**Subject: Request for Modification and Renewal of the Section 404 Individual Permit and Section 401 Individual Water Quality Certification, and Catawba Riparian Buffer Authorization** for the Widening of NC 150 from the NC 16 Bypass in Catawba County to just west of the US 21/NC 150 Interchange in Iredell County, including the Interchange with I-77. Federal Aid Project No. STP-150(19), Division 12, TIP No. R-2307 and I-5717.

**References:** 1) Section 404 Individual Permit, Action ID No. SAW-2018-02343, issued September 3, 2020;  
2) Section 401 Individual Water Quality Certification and Catawba Riparian Buffer Authorization, NCDWR Project No. 20181732, issued April 17, 2019

The purpose of this letter is to request renewal of the existing U. S. Army Corps of Engineers (USACE) Section 404 Individual Permit and N.C. Division of Water Resources (NCDWR) Section 401 Water Quality Certification (WQC) and Catawba Riparian Buffer Authorization.

PERMIT DRAWING
SHEET 8 OF 22

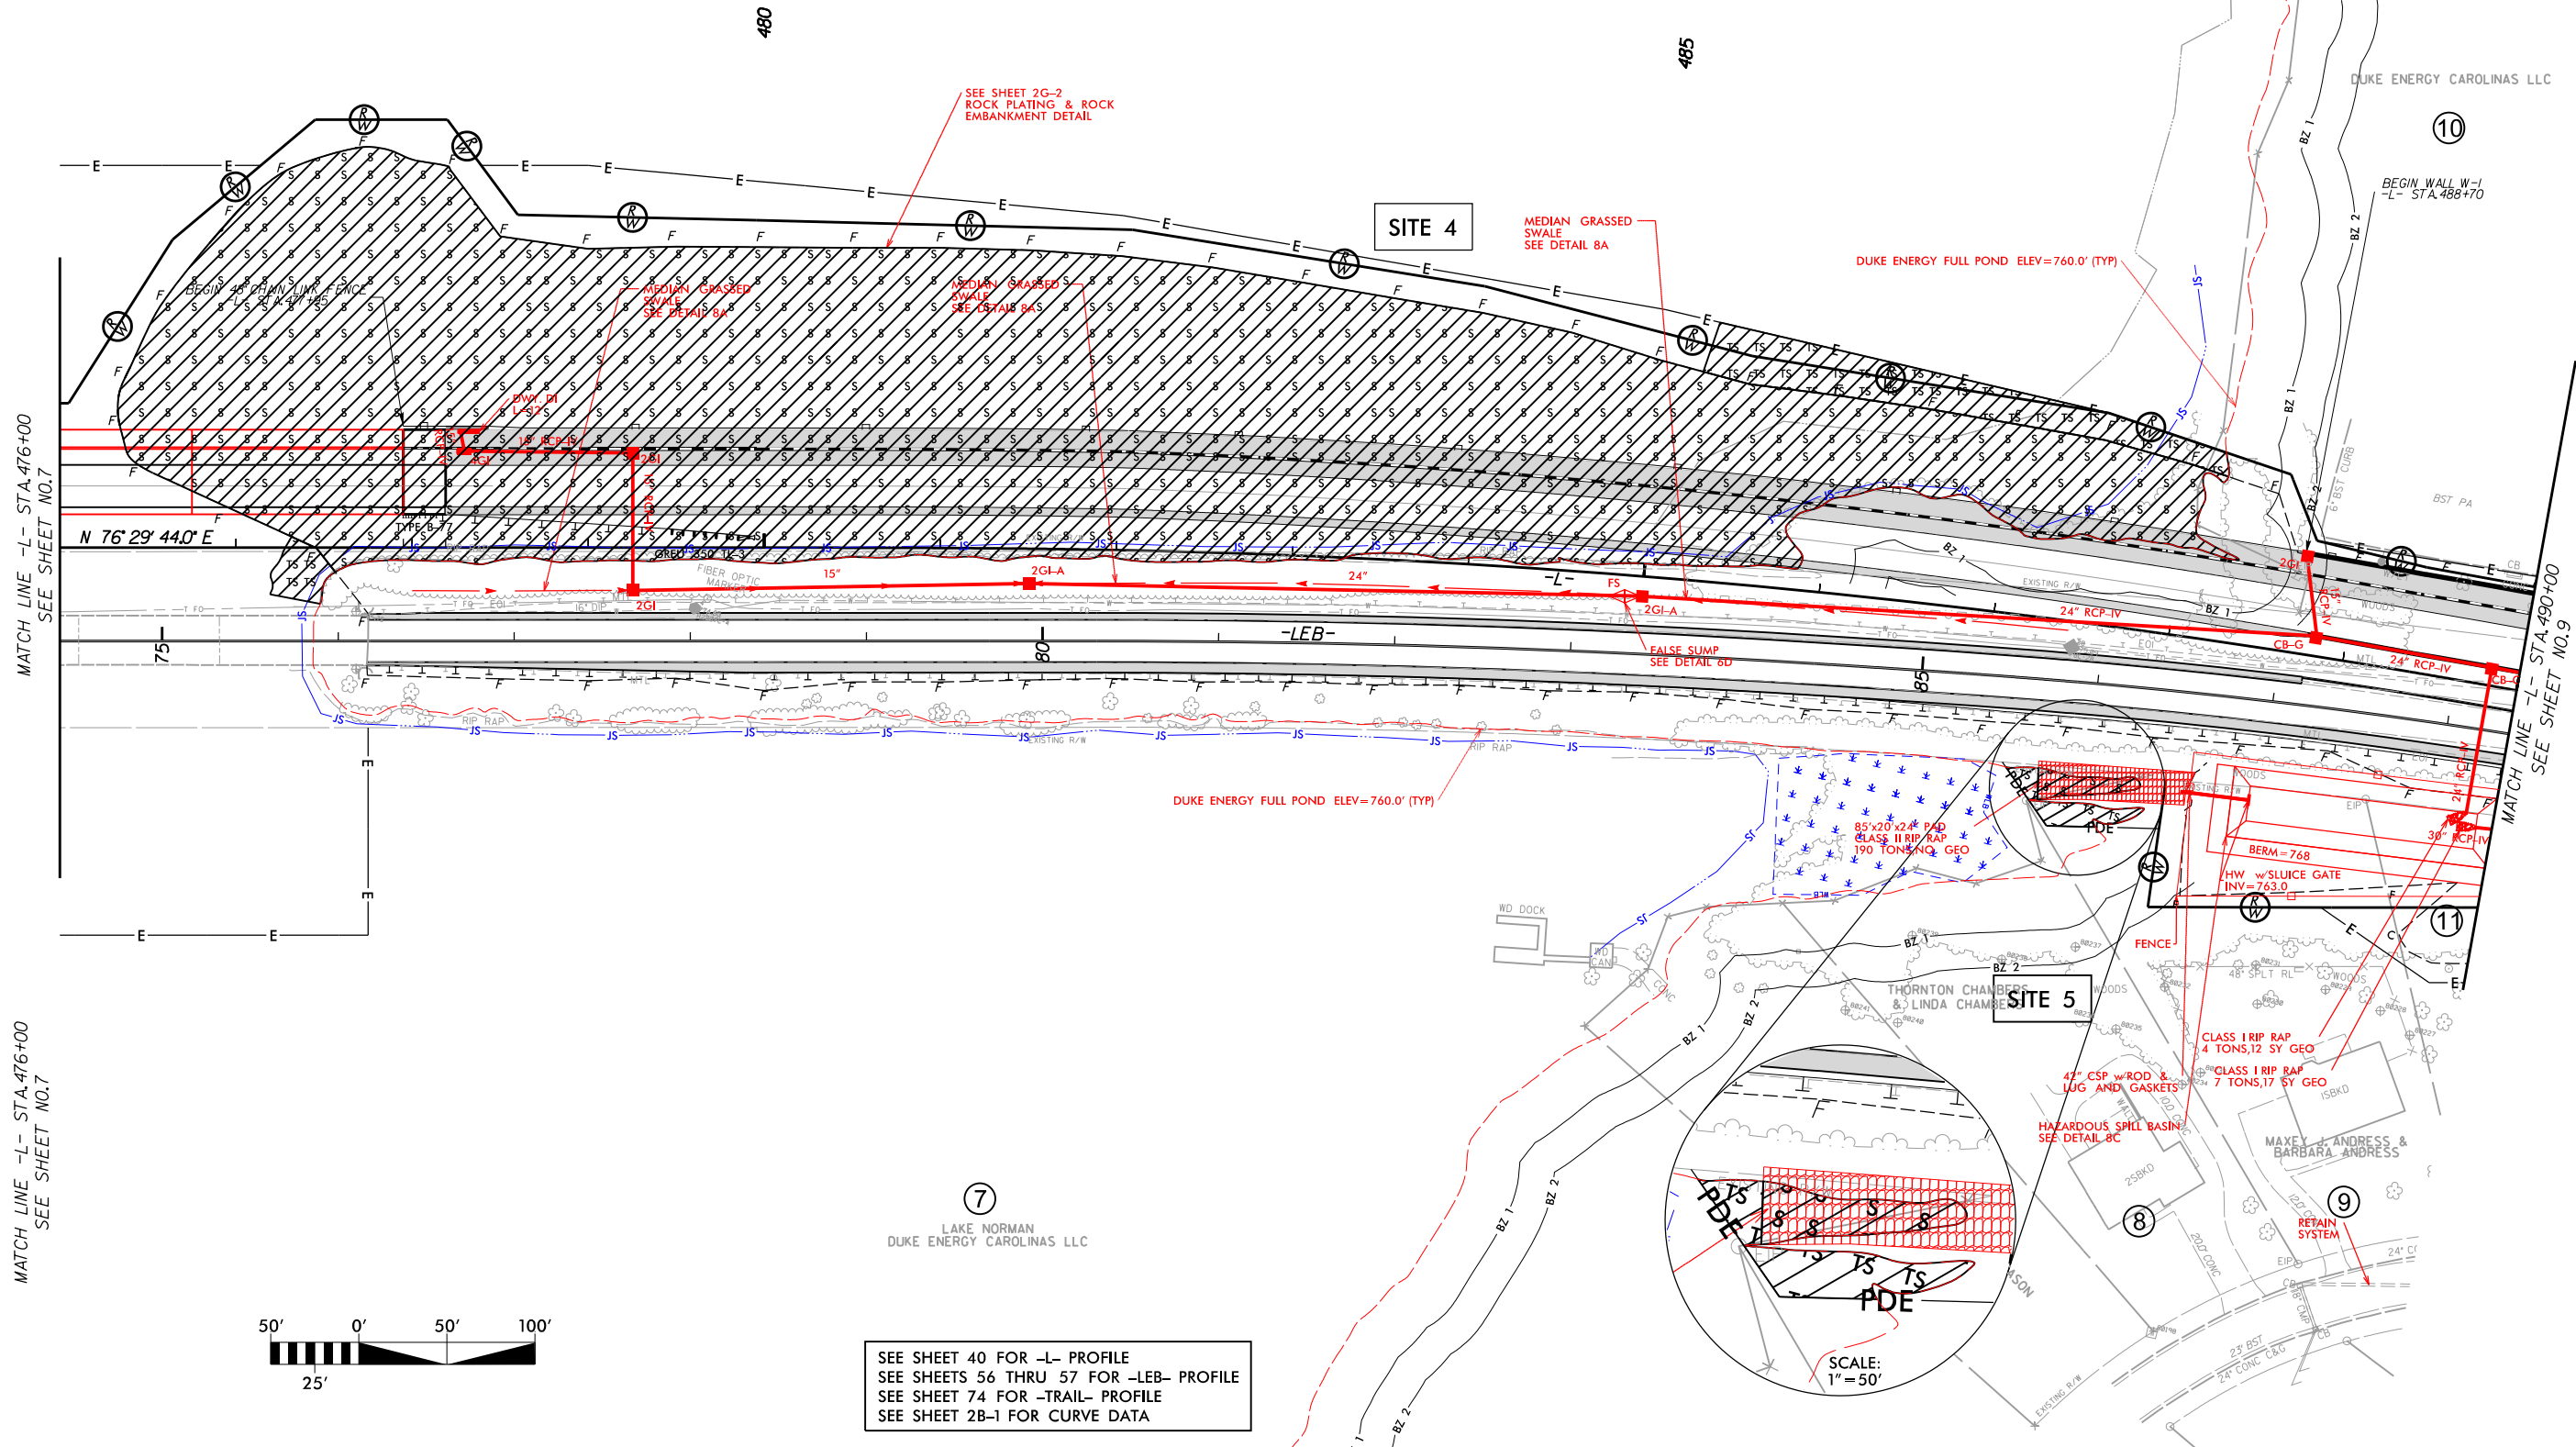
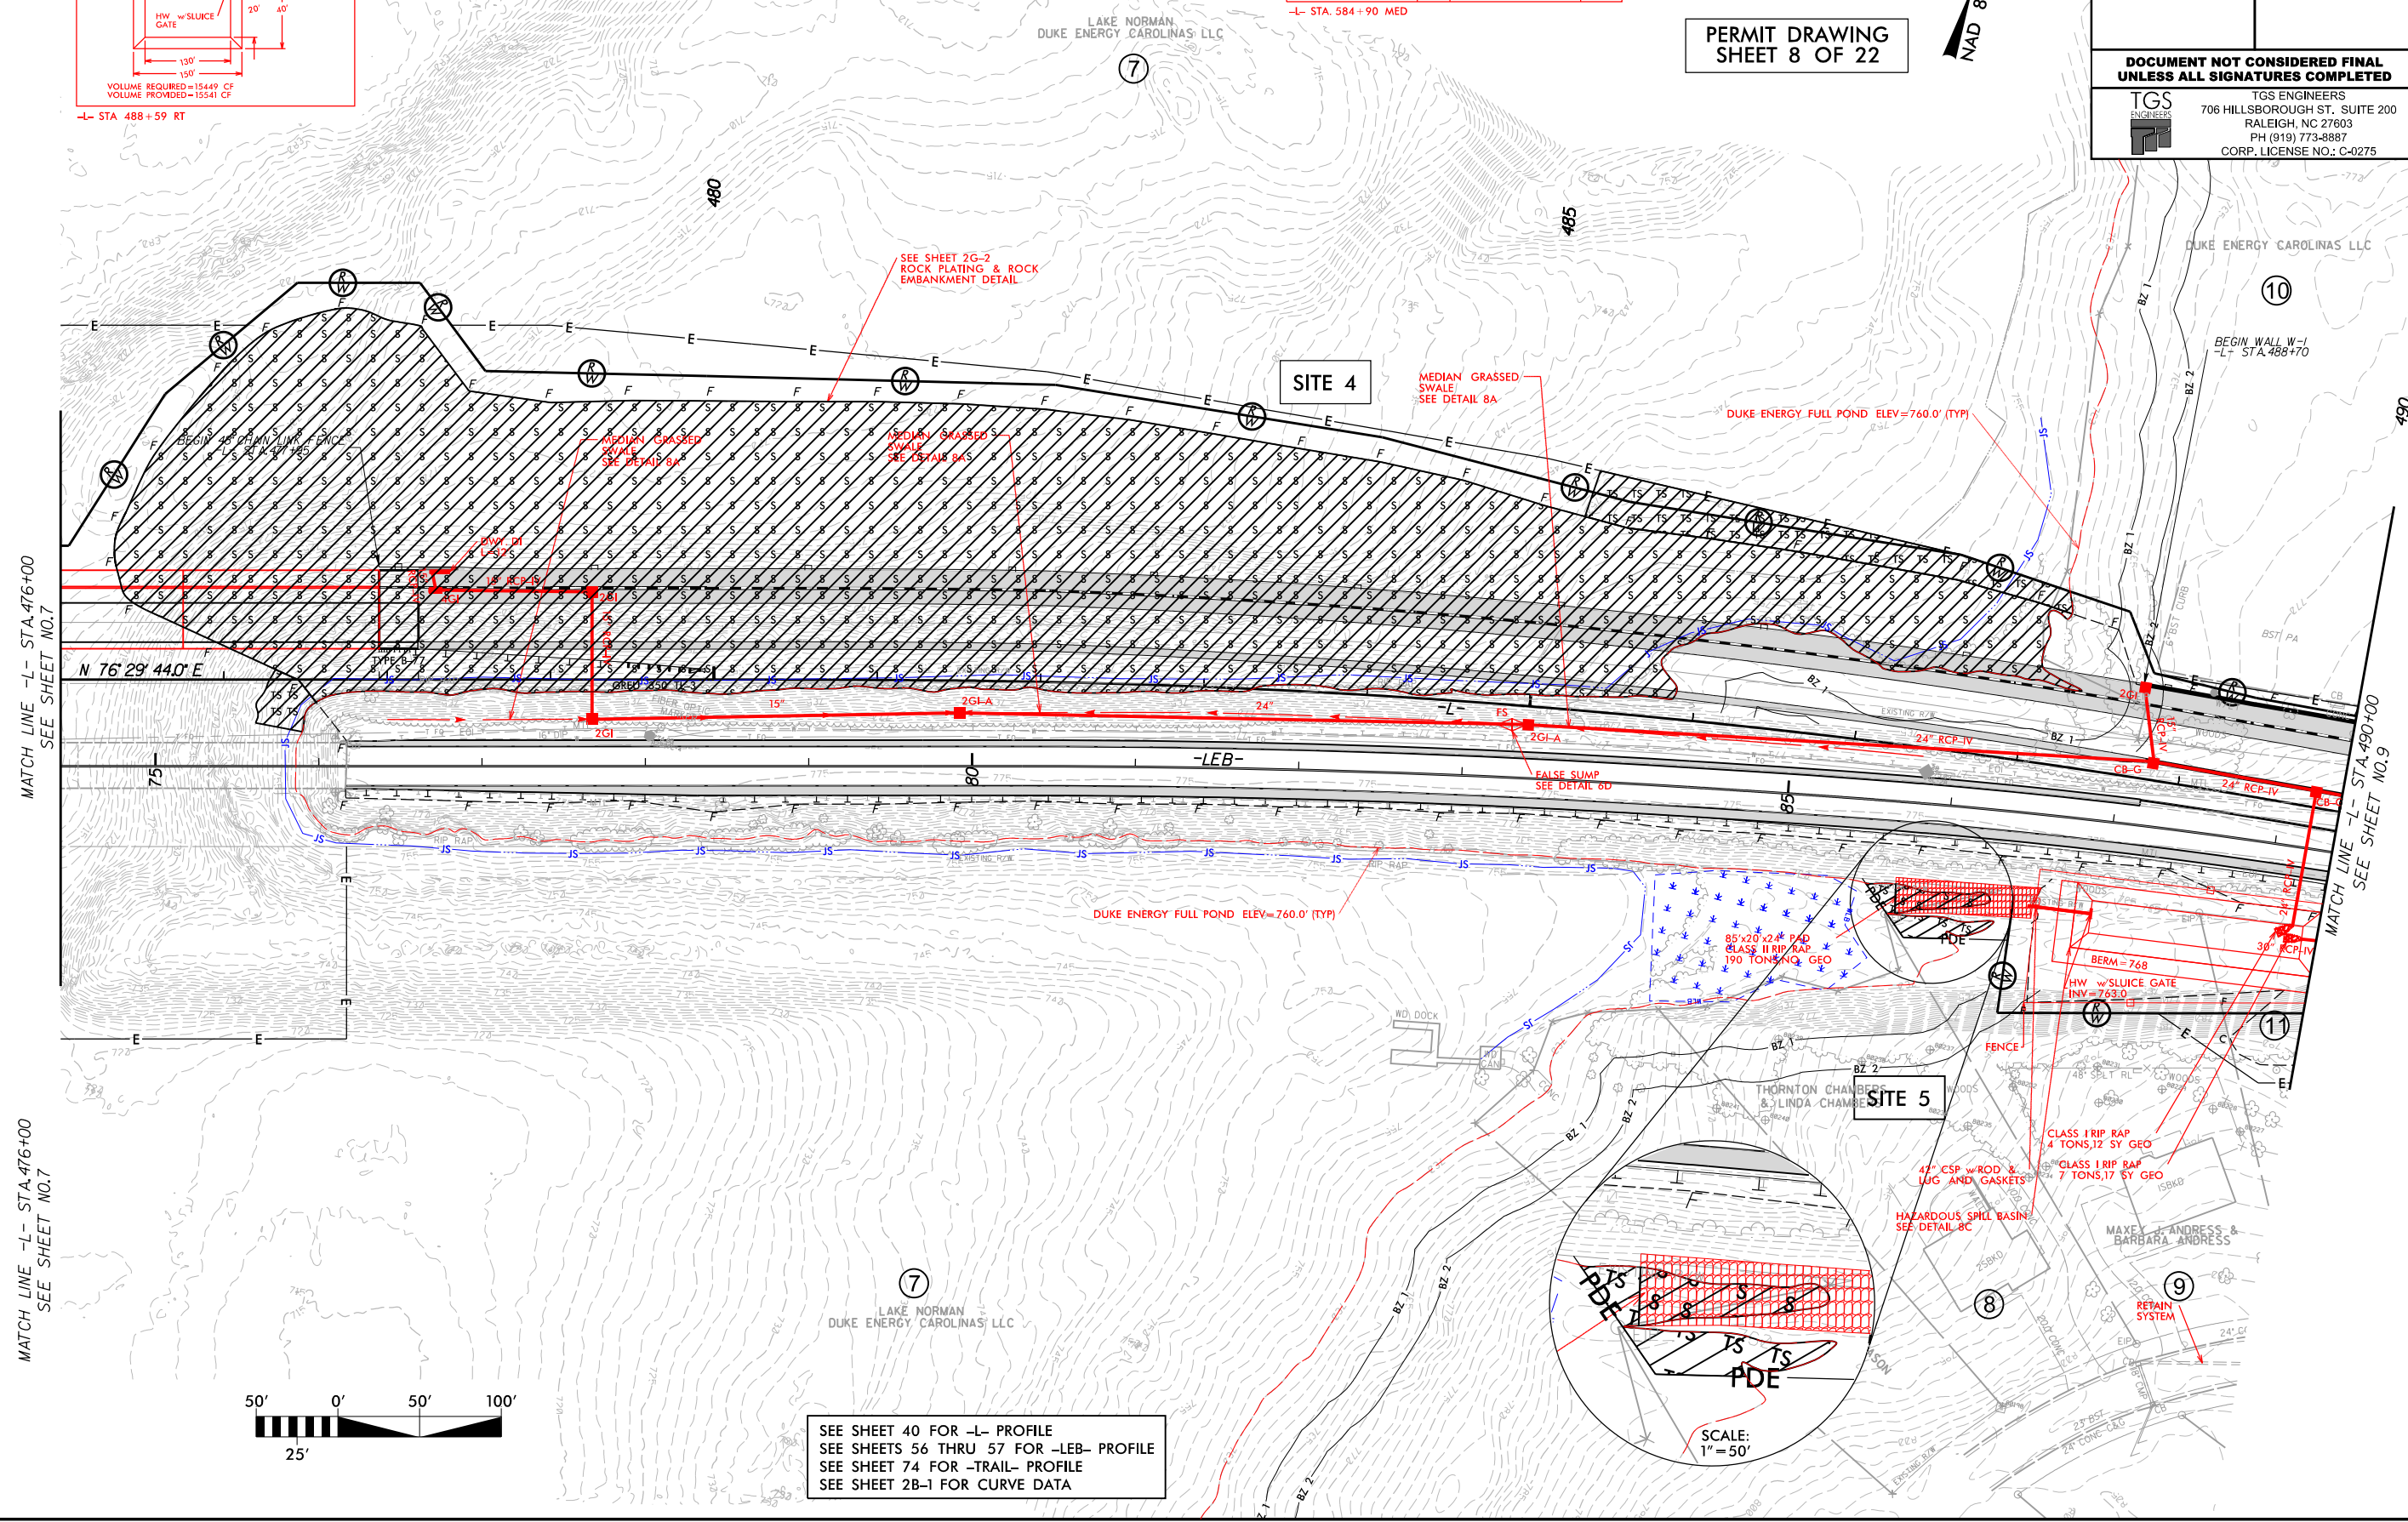
4. Site 4: Permanent Surface Water Impacts decreased from 3.91 acres to 3.859 acres due to minor slope changes at Lake Norman.
5. Site 4: Two temporary Surface Water Impacts were added down to elevation 750 ft on Permit Drawing Sheets 7-8. Temporary Surface Water Impacts increased from 0 to 0.162 acre.
